Planning Application Ref: Y/91/17/OUT

Location: Land at Bilsham Road, Yapton

Description of works: Outline application for the development of up to 250 residential dwellings (Class C3) vehicular access, public open space, ancillary works and associated infrastructure. Departure from the Development Plan

Comments on Application:

| Drawing title: Tree Retention Plan                                                    |                |                      |

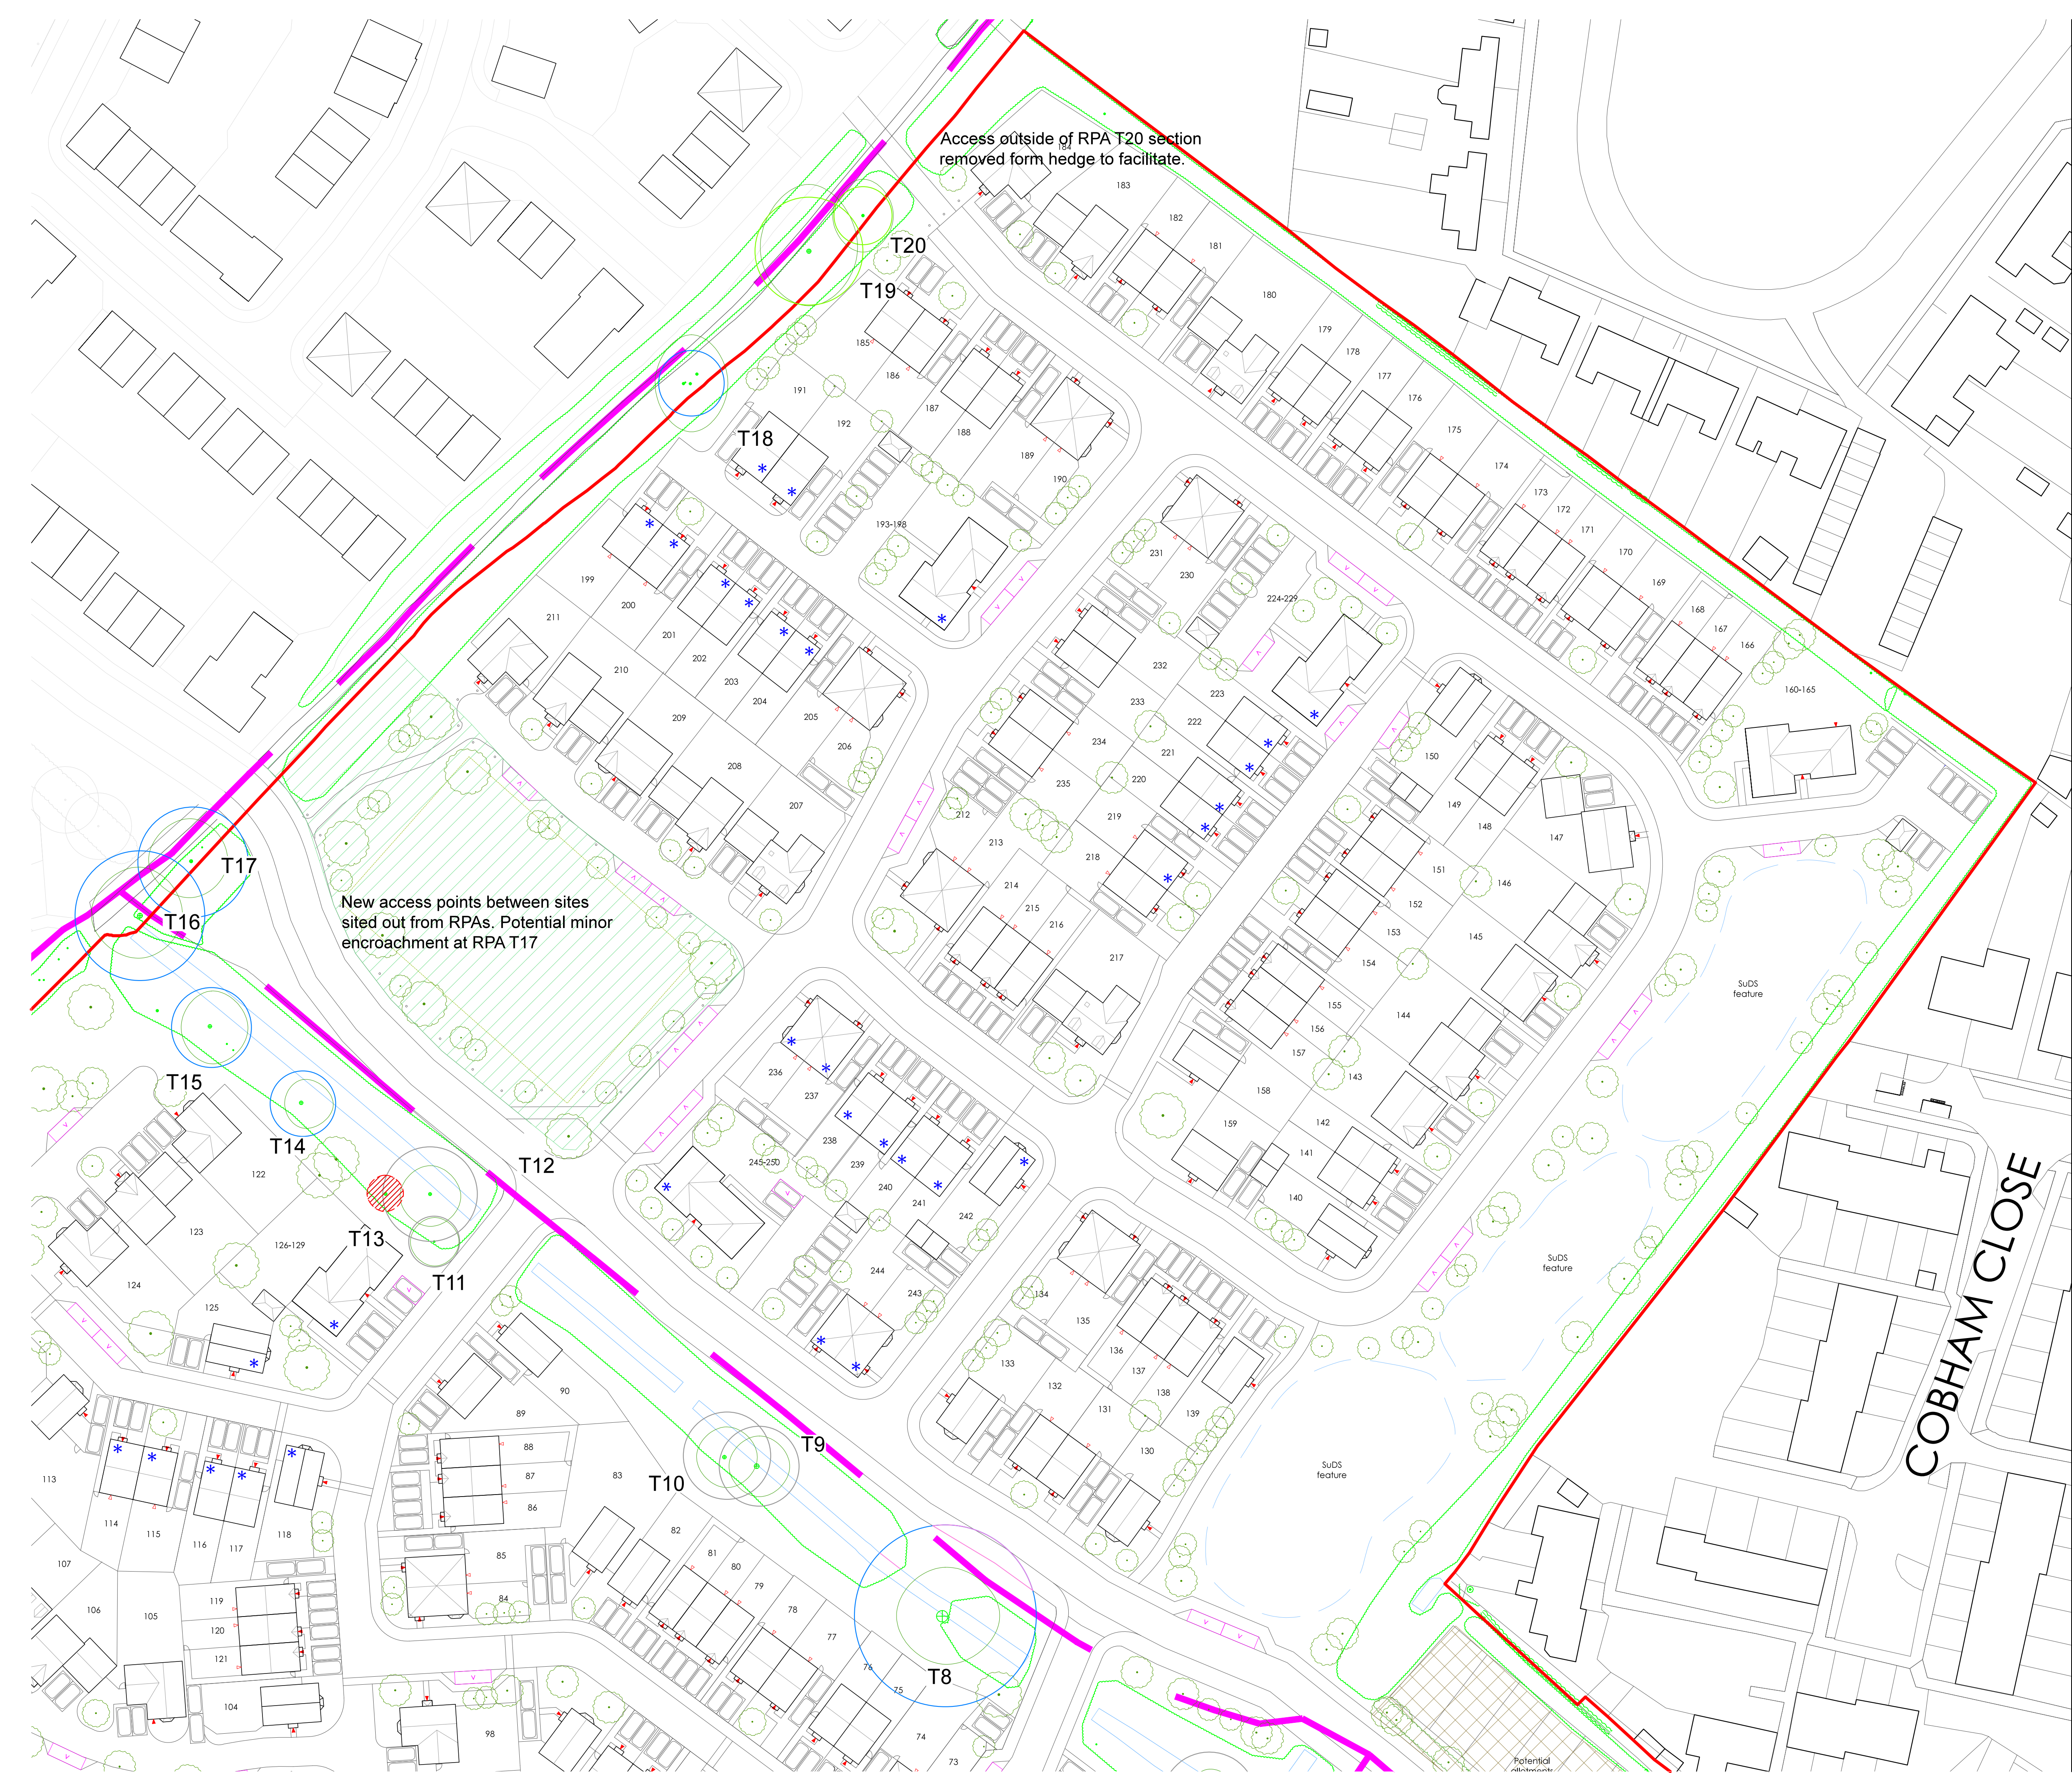
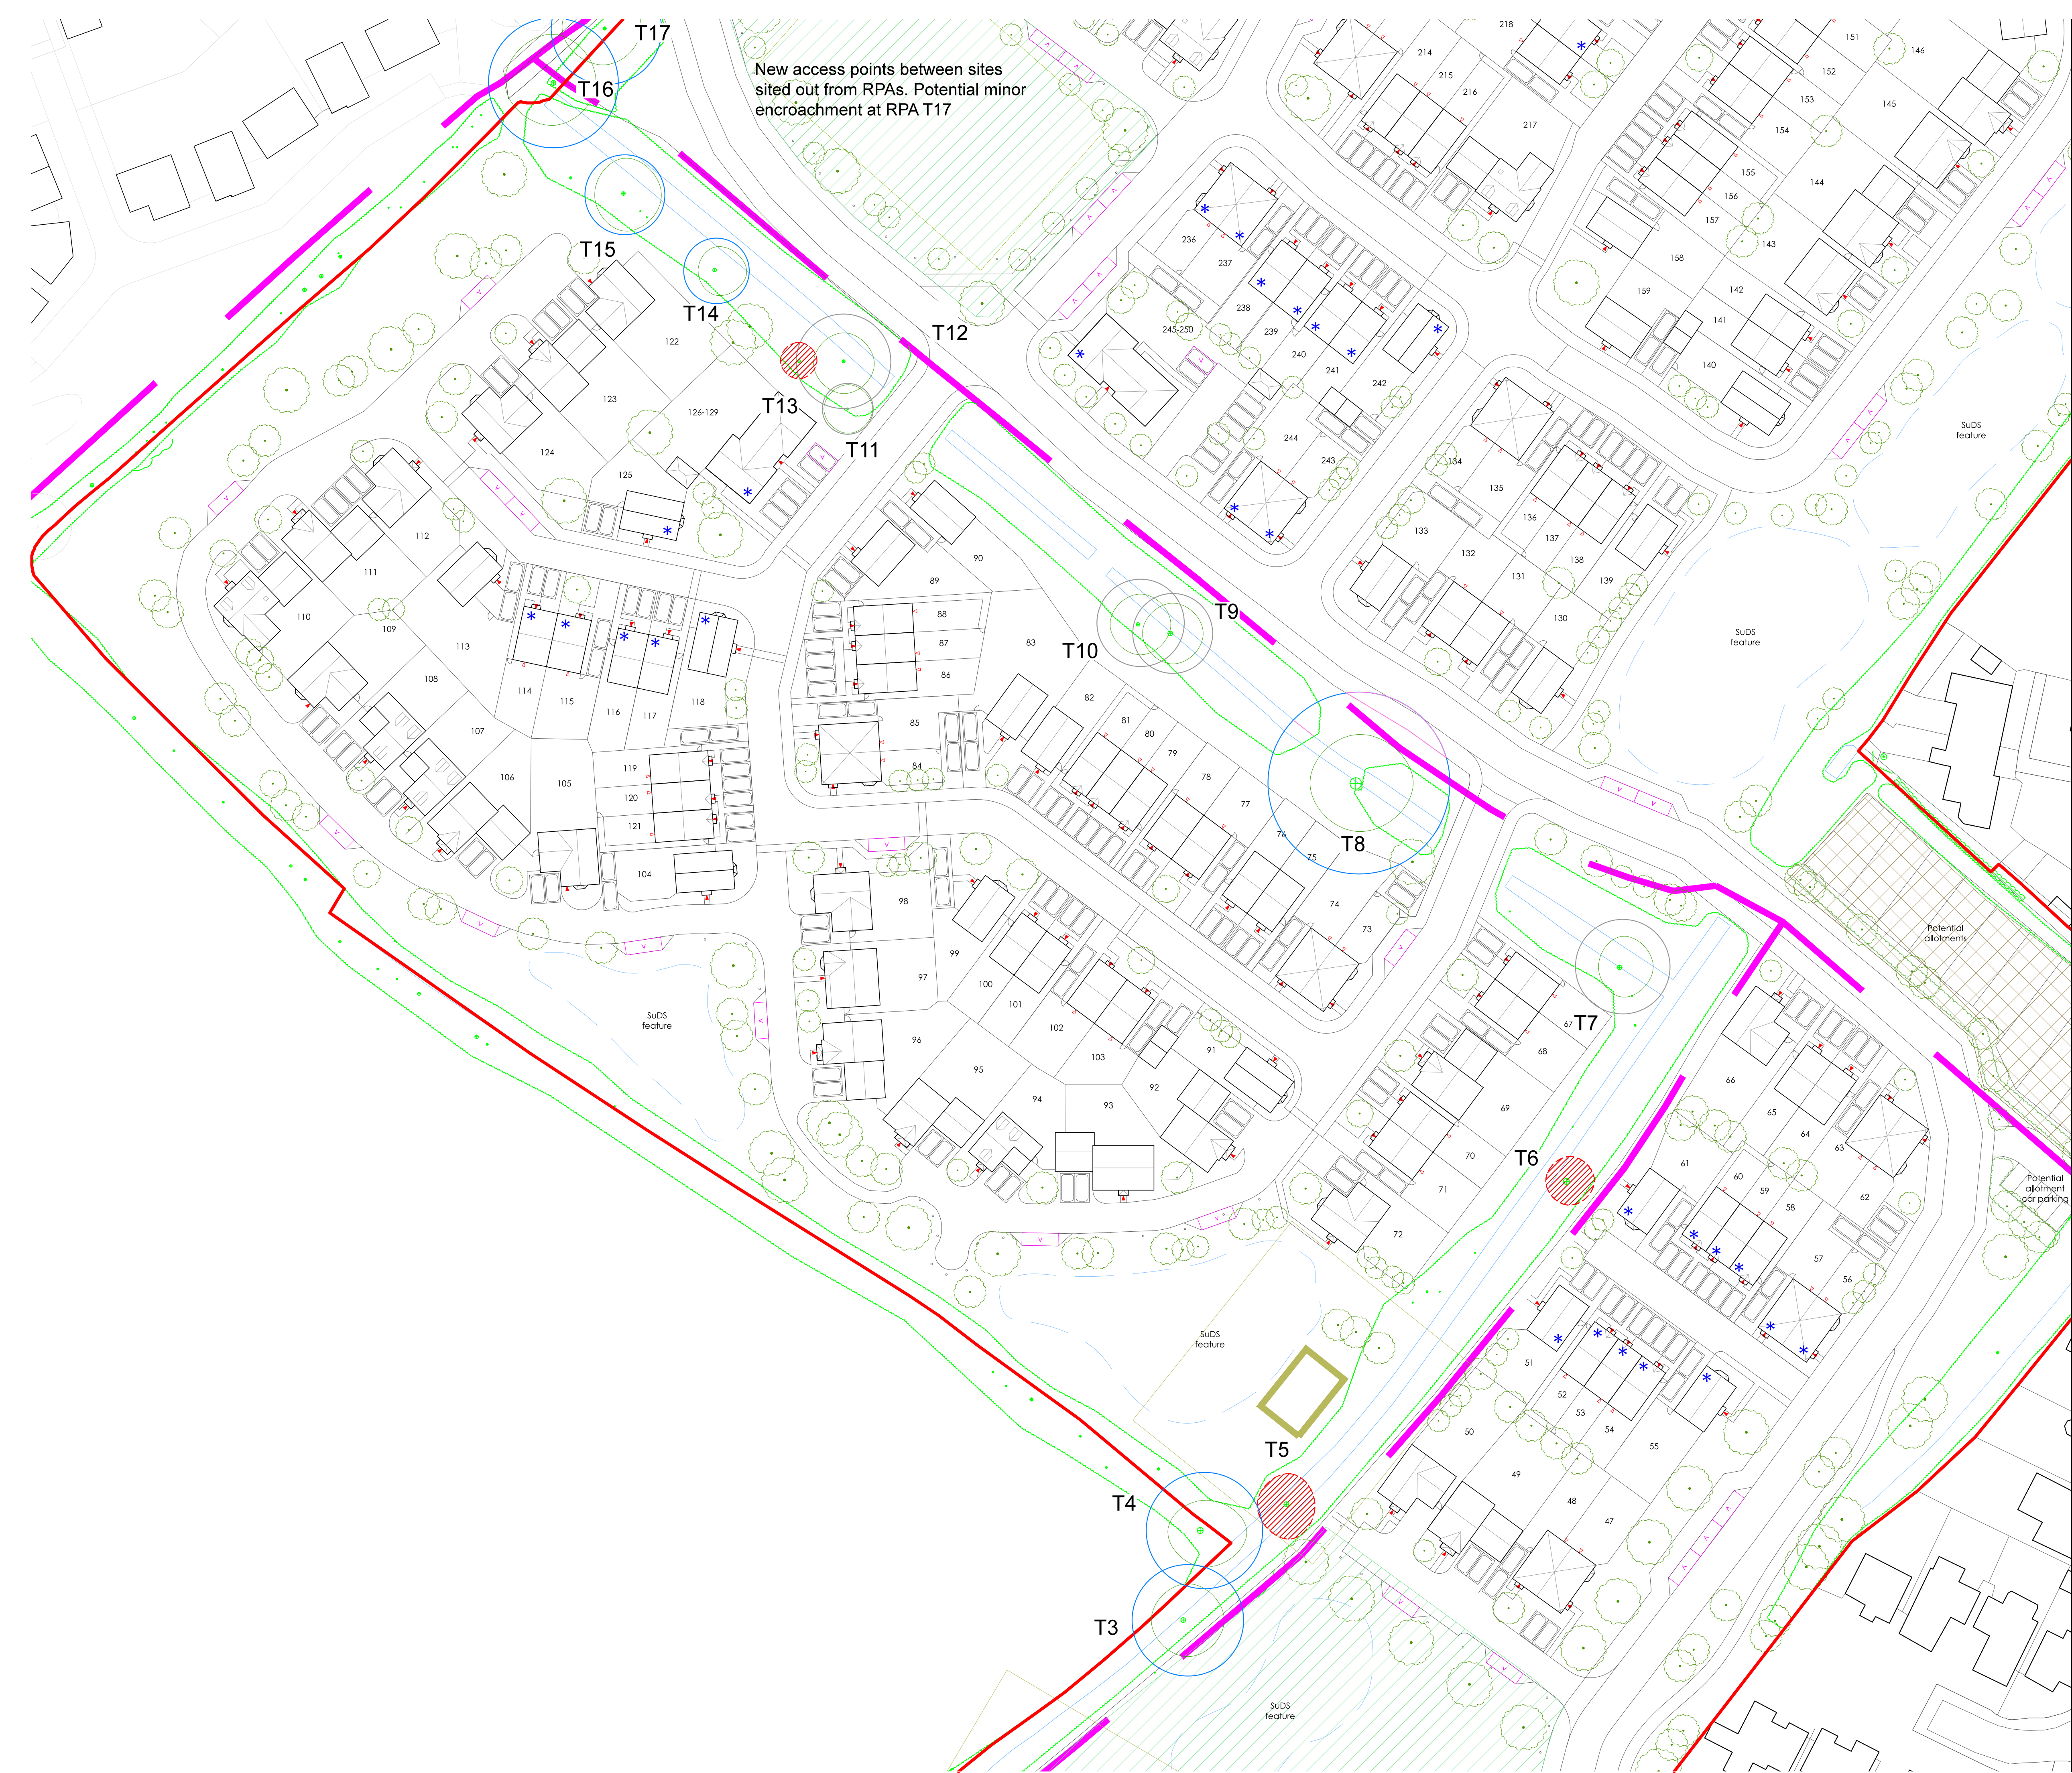
- The applicants employed the PJC Consultancy back in November 2017 to undertake a tree survey and then prepare an Arboricultural Impact Assessment (AIA) PJC/4699/17-02 R2. Tree Survey data is adequate at this stage and broadly accords with the requirements of BS5837:2012. I have referred to Illustrative detailed masterplan drg. 1244G.03 to assist with determining the accuracy of the Tree Constraints and Tree Retention Plans submitted by PJC with their AIA report. This allows me to gain a general understanding of how the plot layout and access routes relate to trees but is not specific enough for me to have full confidence they will be adequately respected and protected.

- I am pleased to see there is intent to retain the vast majority of recorded trees in harmony with the development, but I cannot be satisfied that this will be achievable until we receive a Tree Protection Plan (TPP) overlaying the final proposed site design layout, with supporting Arboricultural Method Statement (AMS) where RPA incursion is anticipated - which I would expect to see submitted with a subsequent full planning application.

- At this outline stage, the indicative layout and access arrangements and the appointed arboriculturalist's general regard for significant trees existing on site are encouraging and I am in broad agreement with their survey information. That said, I am concerned that there appear to be notable omissions in respect of existing tree cover along several sections of the site perimeter (South, adjacent arable farmland – East, rear of The Millers – North, south of dwellings at Tack Lee Road). This may be deliberate as the proposed design does not at this stage suggest any direct interference with them but it is important to consider all trees whether they are on or off-site and within potential influencing distance, so as to inform the site layout design which may of course be subject to revision. Any omissions will need to be addressed and therefore included in the aforementioned TPP and AMS should this proceed to a full planning application.
